IN RESPONSE TO ITEM 5.1 & 5.5
REFER TO DRAWING NO. KSG4-CSC-XX-XX-DR-C-0036
WHICH SHOWS ADEQUATE MANOEUVRABILITY IS ACHIEVABLE WITHIN THE PROPOSED DEVELOPMENT AND ADEQUATE STOPPING DISTANCES HAVE BEEN ACHIEVED.

Architect	Project	Title
DTA	Kishoge Part 10 Application	Site 4 Quality Audit
Date	08/02/25	08/02/25
Scale	1:500	1:500
Author	SC	JF
Checker	SC	JF
Approver	SC	JF
Reviewer	SC	JF
Final	SC	JF

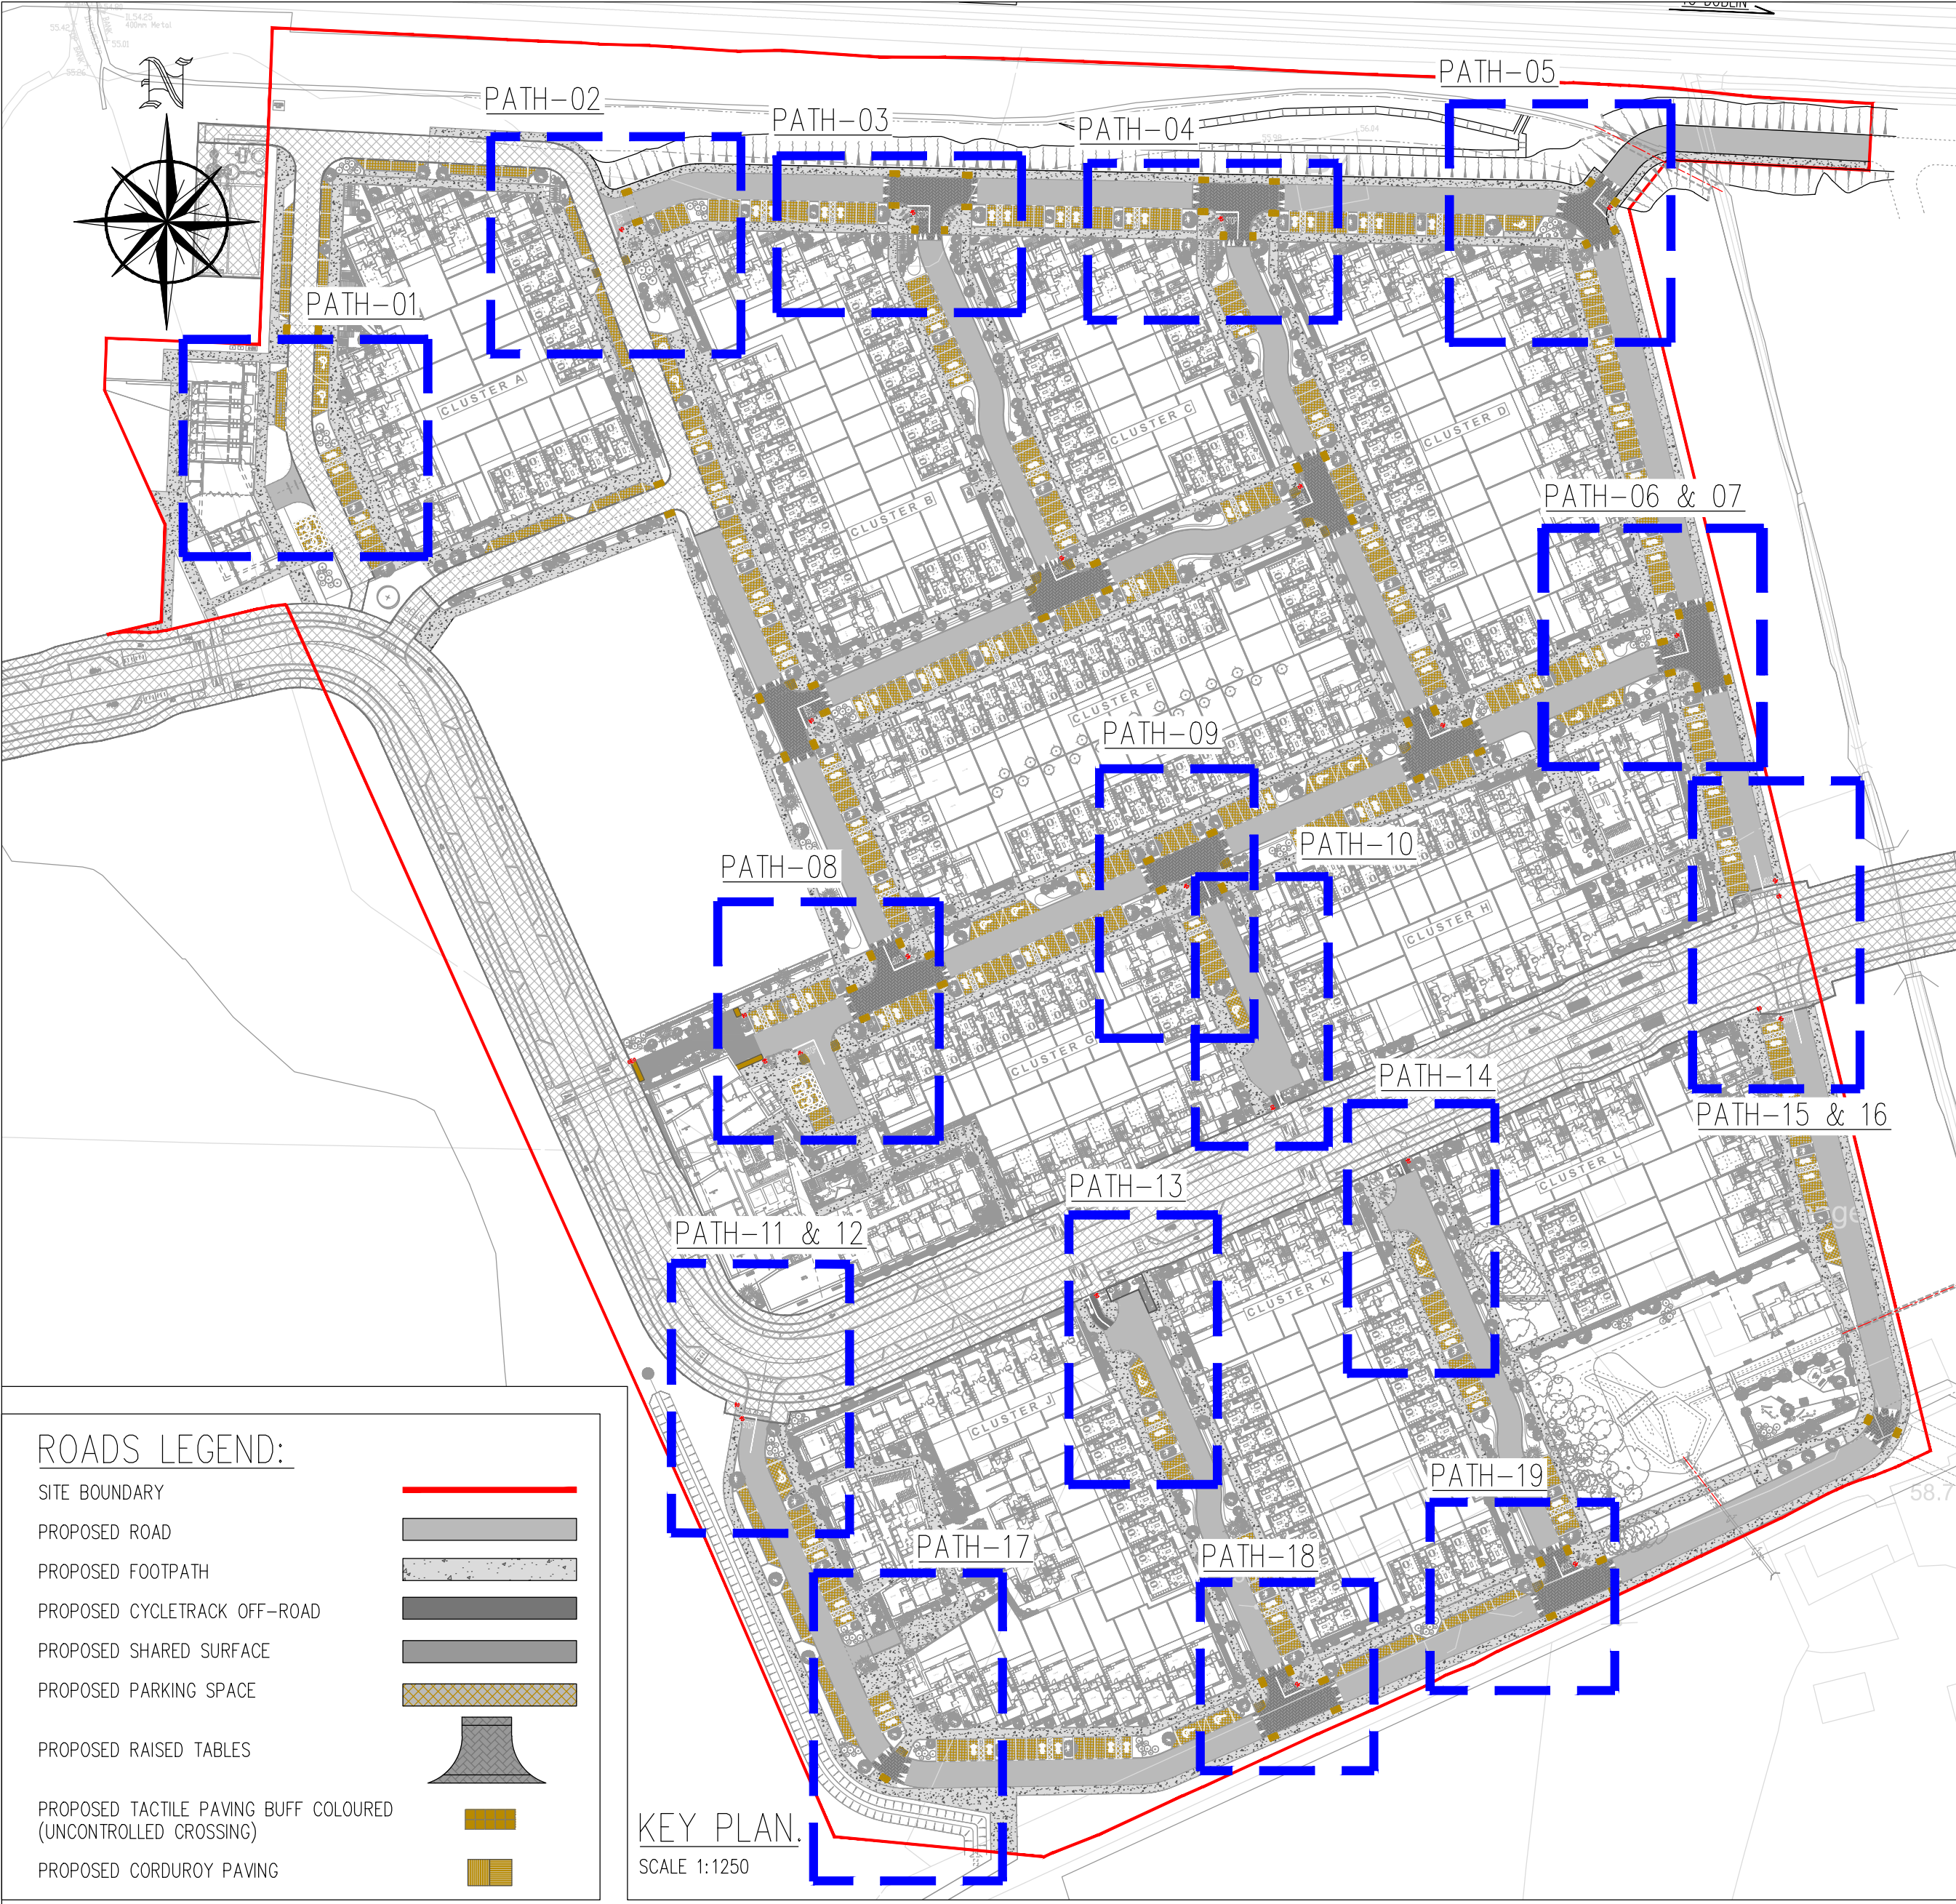
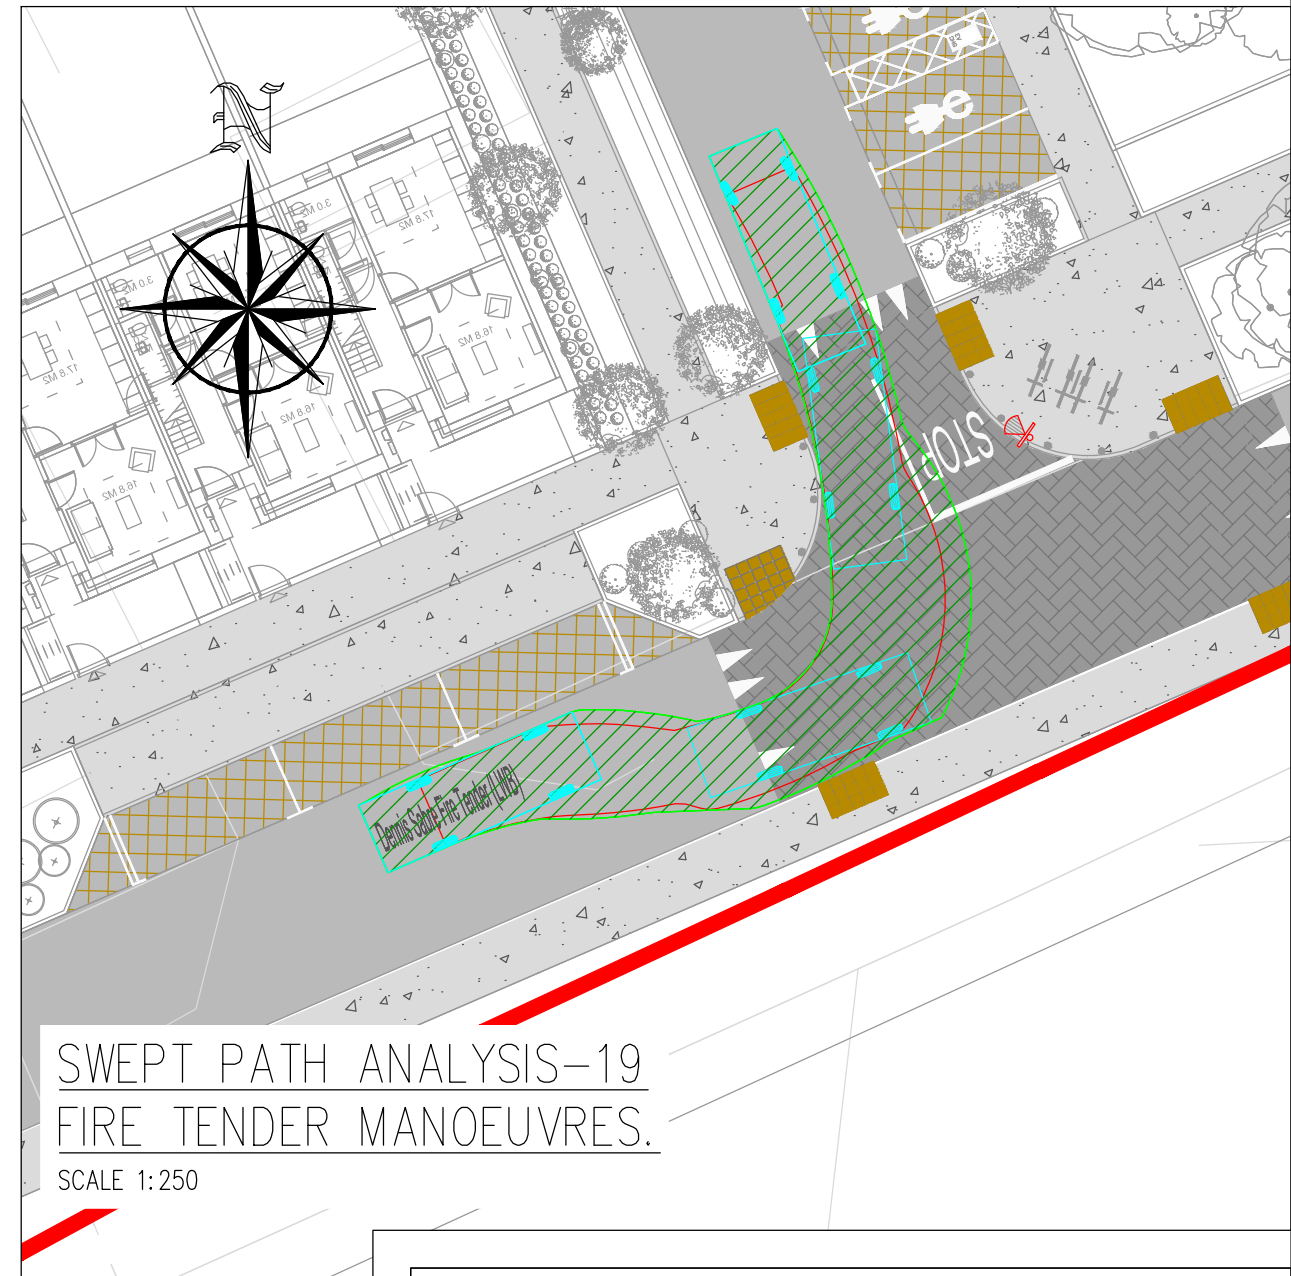
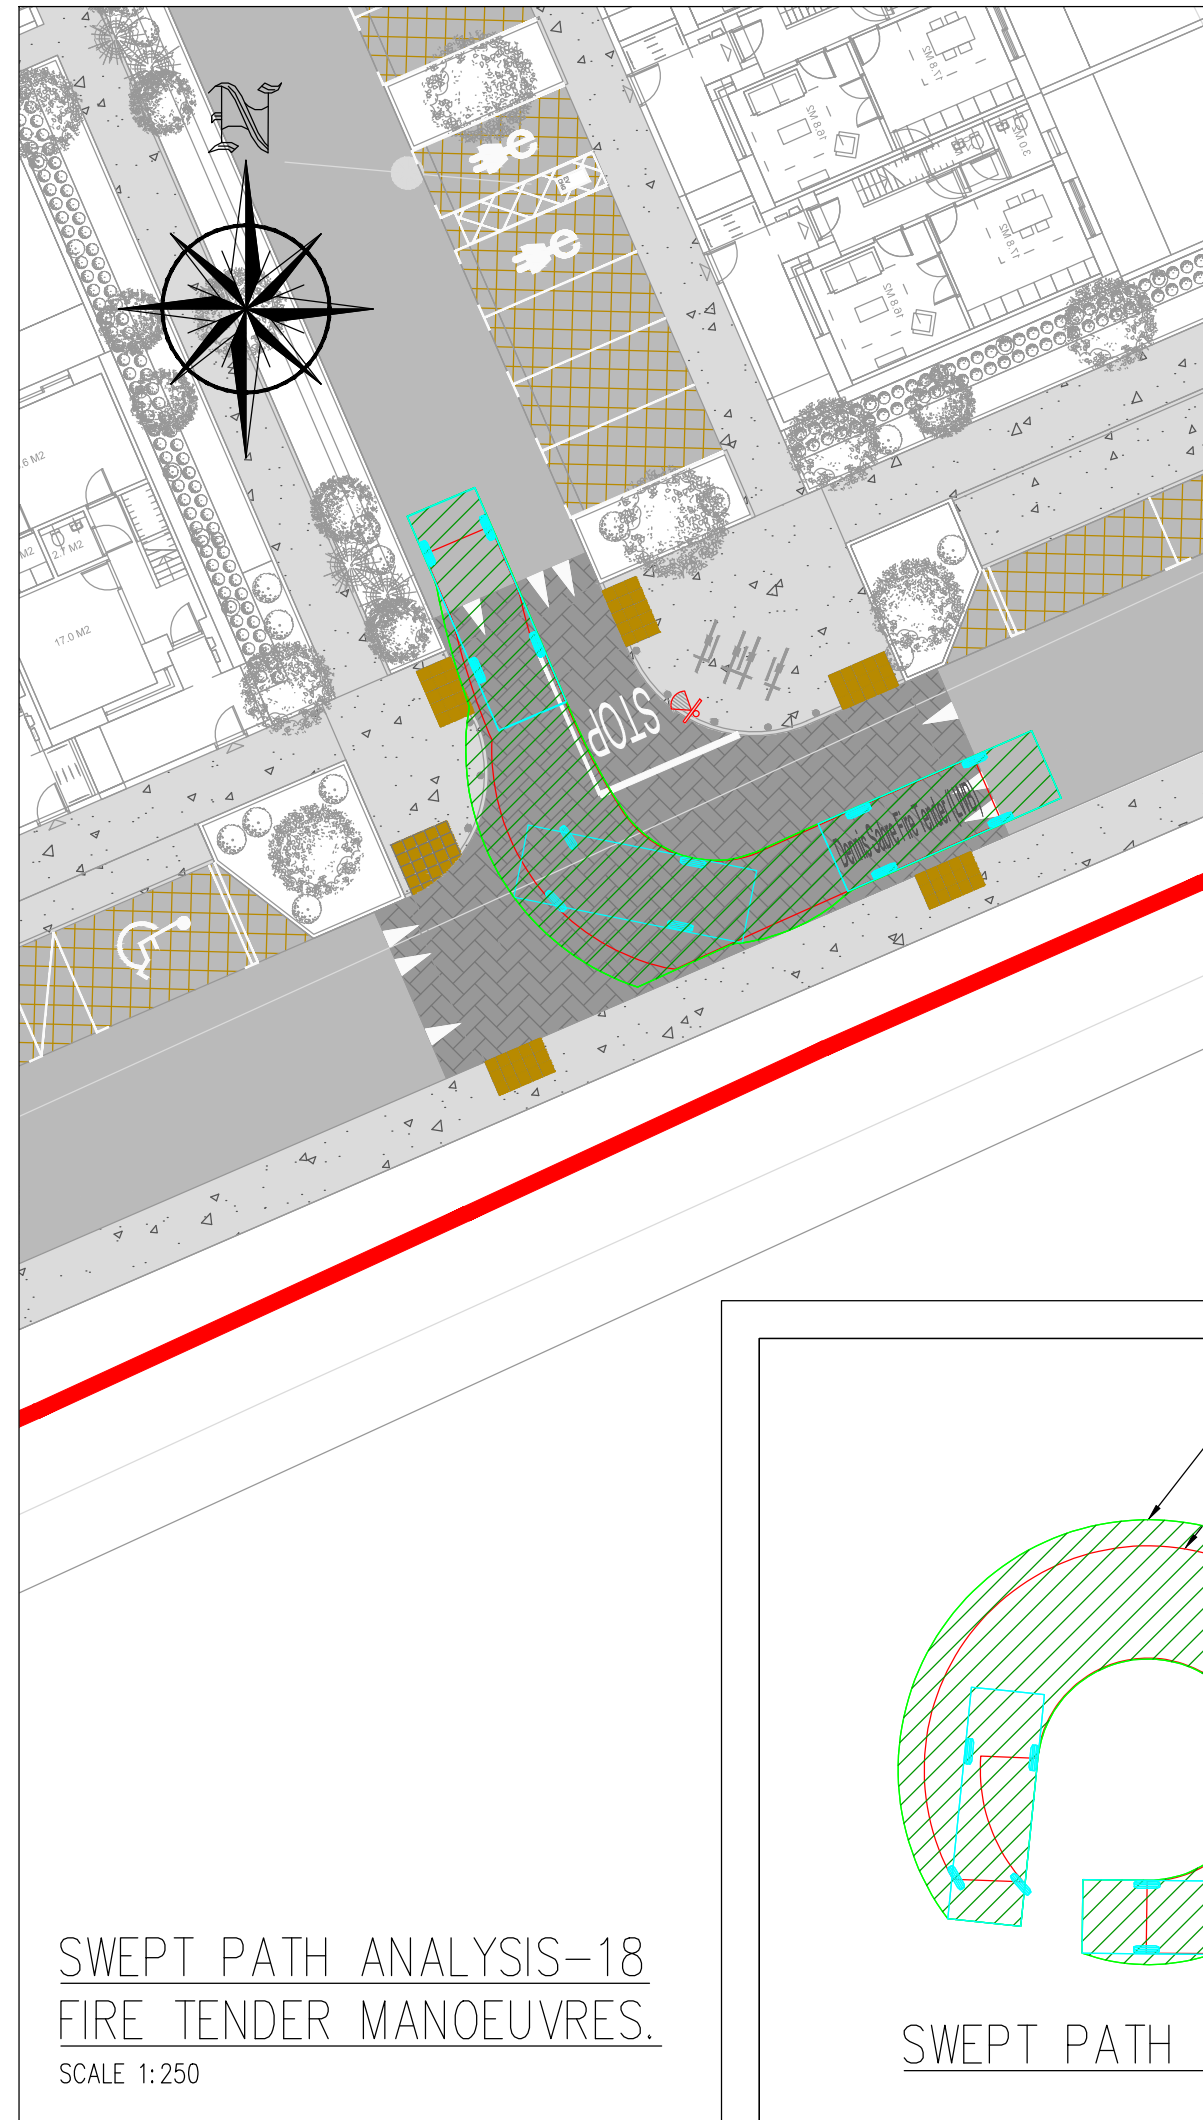
IN RESPONSE TO ITEM 5.2
REFER TO DRAWING NO. KSG4-CSC-XX-XX-DR-C-0016 & 0017
WHICH SHOWS ADEQUATE FIRE TENDER AND REFUSE VEHICLE MANOEUVRABILITY IS ACHIEVABLE WITHIN THE PROPOSED DEVELOPMENT.
